REQUEST

Proposed Zoning: IMU(CD) (Innovation Mixed-Use, conditional)
Approximately 7.4 acres along the southwest side of Brookshire Boulevard and the southeast side of Fred D Alexander Boulevard.

STAFF RECOMMENDATION

PLANNING STAFF REVIEW

SHEET NO.  
**RZ-100**

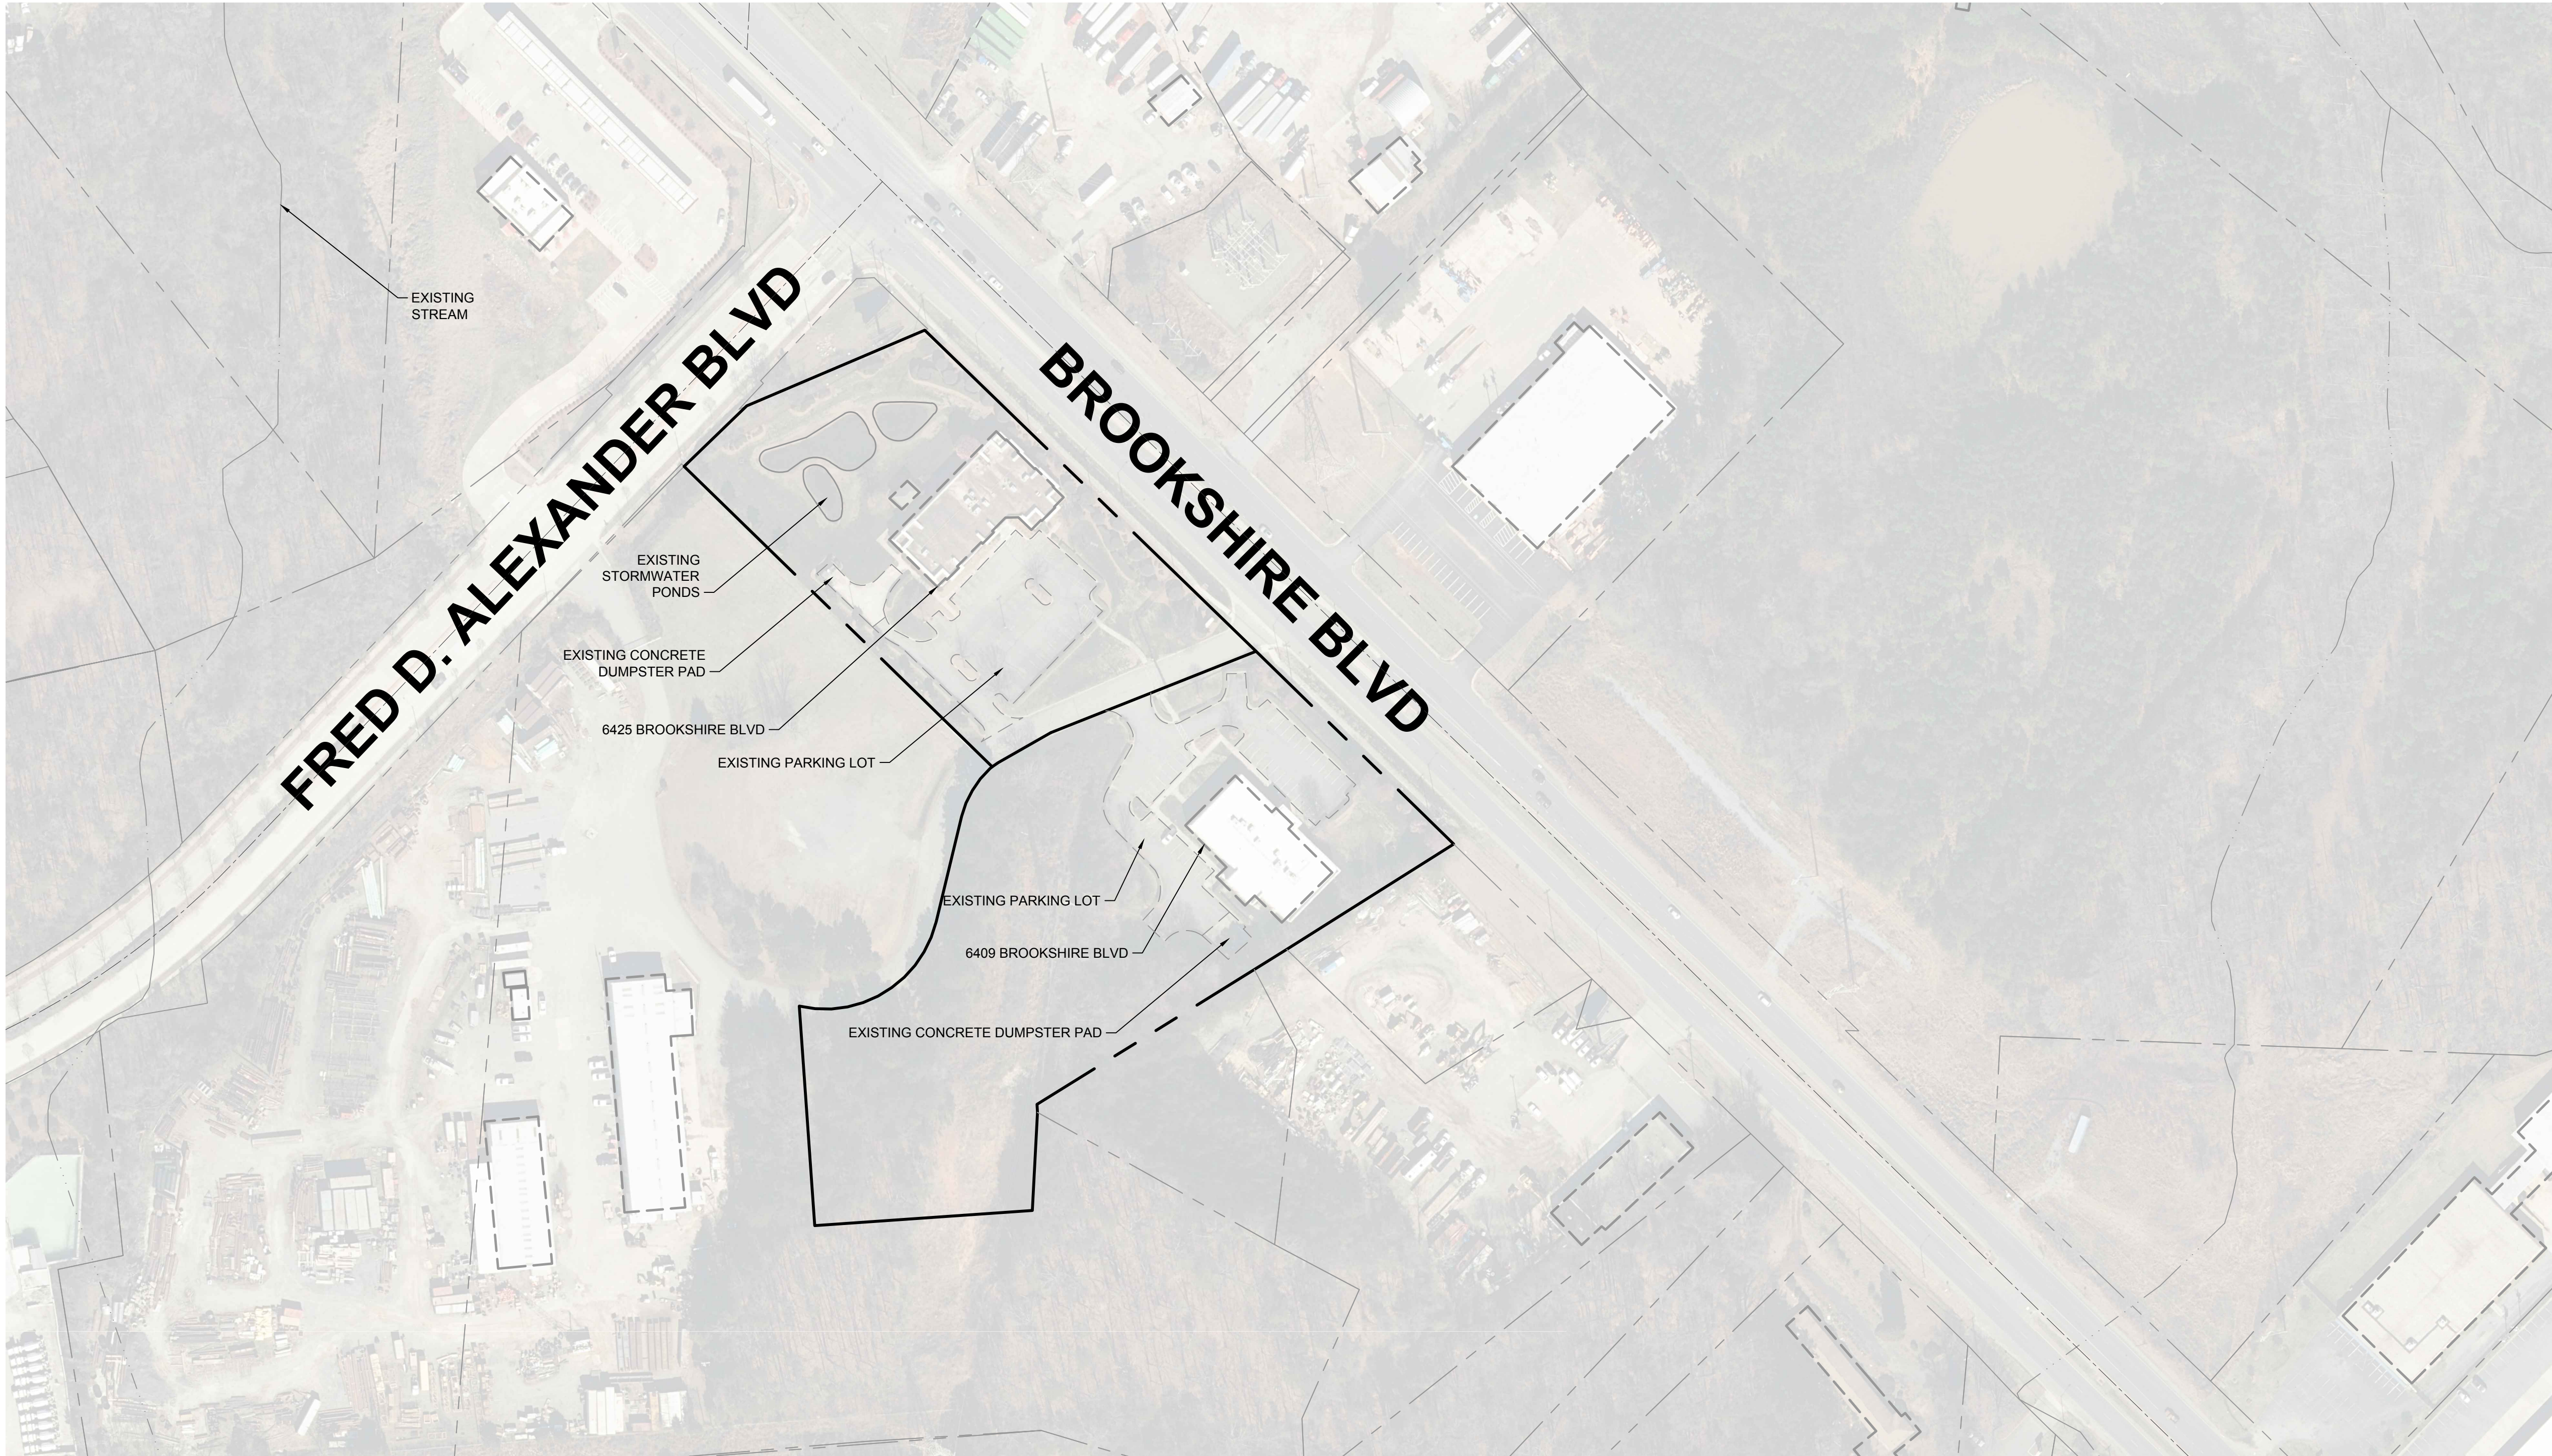
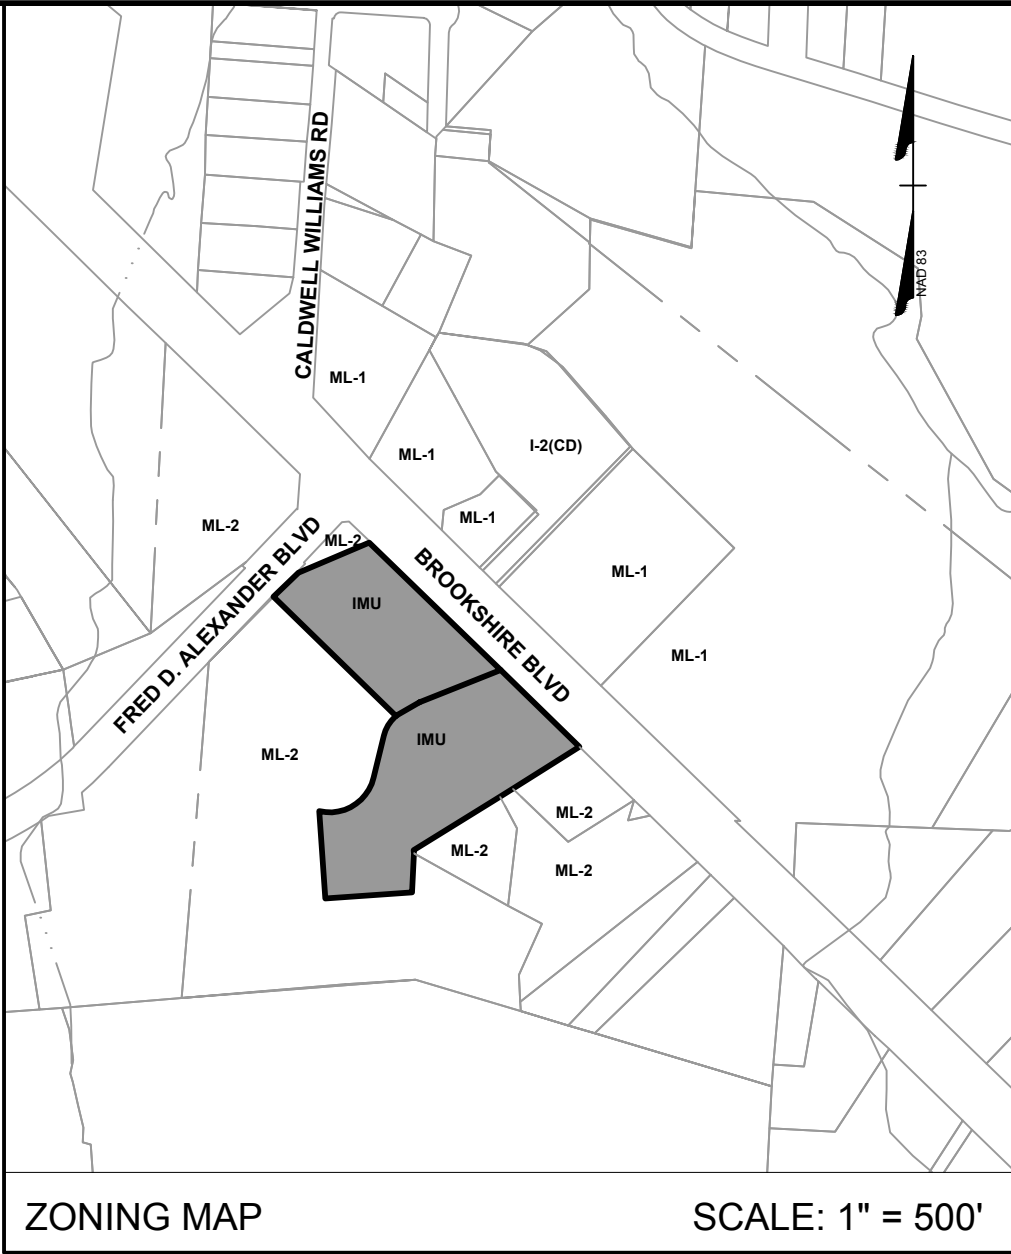
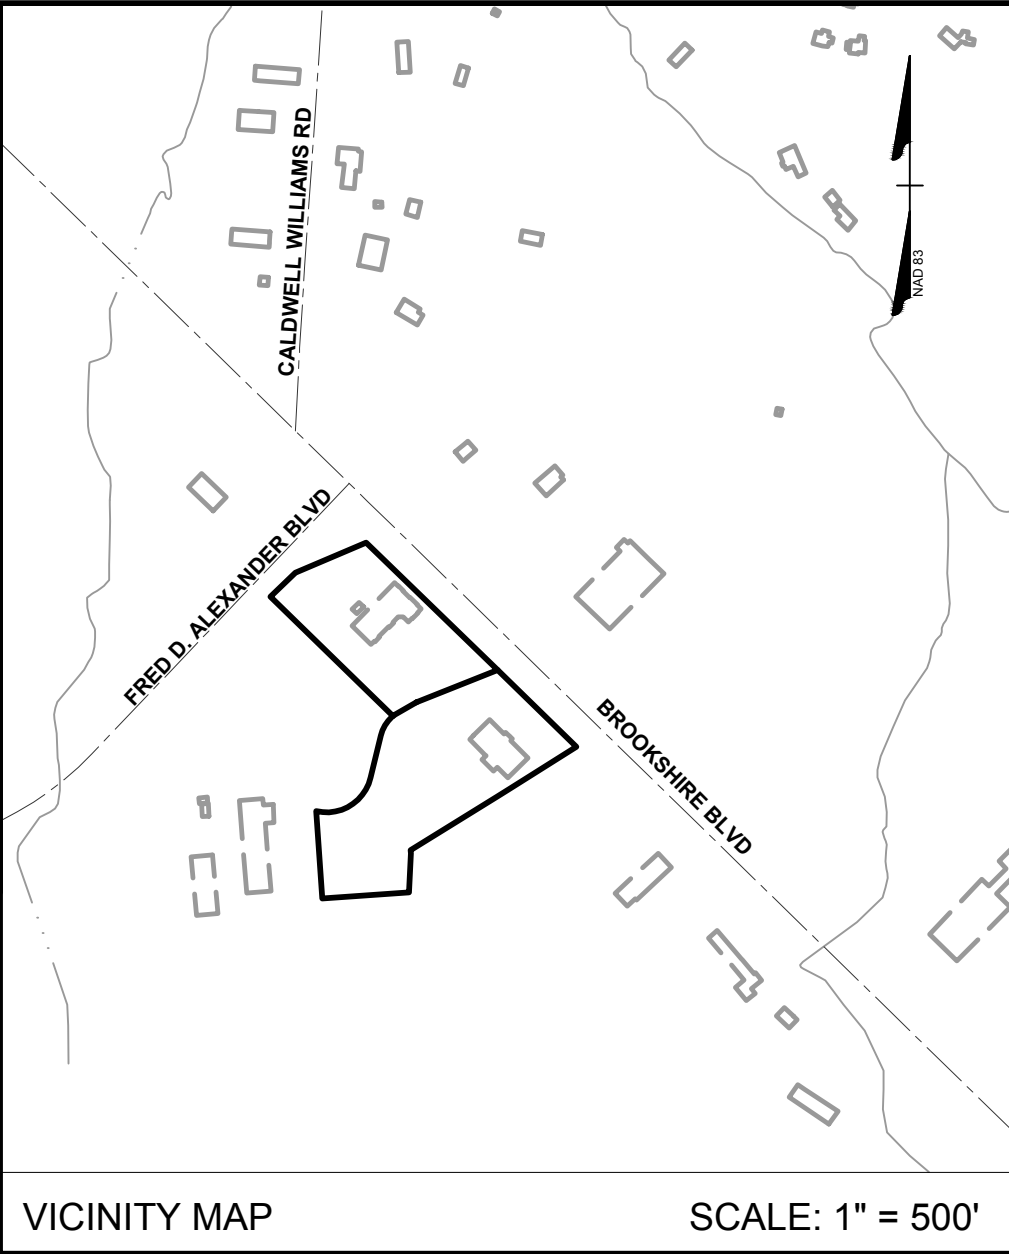
1. CDOT: **Fred D. Alexander Boulevard:** Location of future curb and gutter is to be 41' from centerline. 4+ Boulevard Buffered/Separated Bike Lanes per Charlotte Streets Map. Label and dimension the curb and gutter from the centerline for each road on the site plan.
2. CDOT: Brookshire Boulevard: Location of future curb and gutter is to be 44' from centerline. 6+ Boulevard, Shared Use Path per Charlotte Streets Map. Label and dimension the curb and gutter from the centerline for each road on the site plan.
3. CDOT: ~~Comprehensive Transportation Review (CTR): Square footage needed to determine potential CTR and streetscape requirements. Additional comments or requirements may arise once unit count is provided.~~ **Addressed**

4. Urban Forestry: A tree survey shall be required for all conditional zoning map amendments.
5. Urban Forestry: Update conditional note under General provision 8.B to reference Article 20 of the UDO.

6. ~~Entitlement Services: Update conditional note 2 under general provisions to reference Article 37 of the UDO.~~ **Addressed**
7. Entitlement Services: Update required setback on Brookshire Blvd to 24 feet. **Addressed**
8. Entitlement Services: Add proposed square footage to parcel 03505513. Show area of expansion graphically for parcel 03505512.

9. Urban Forestry: Show heritage trees and trees that are within the right-of-way.

10. CDOT: Current site plan shows 4' planting strip on Brookshire Boulevard this needs to be designed and labeled as 8'
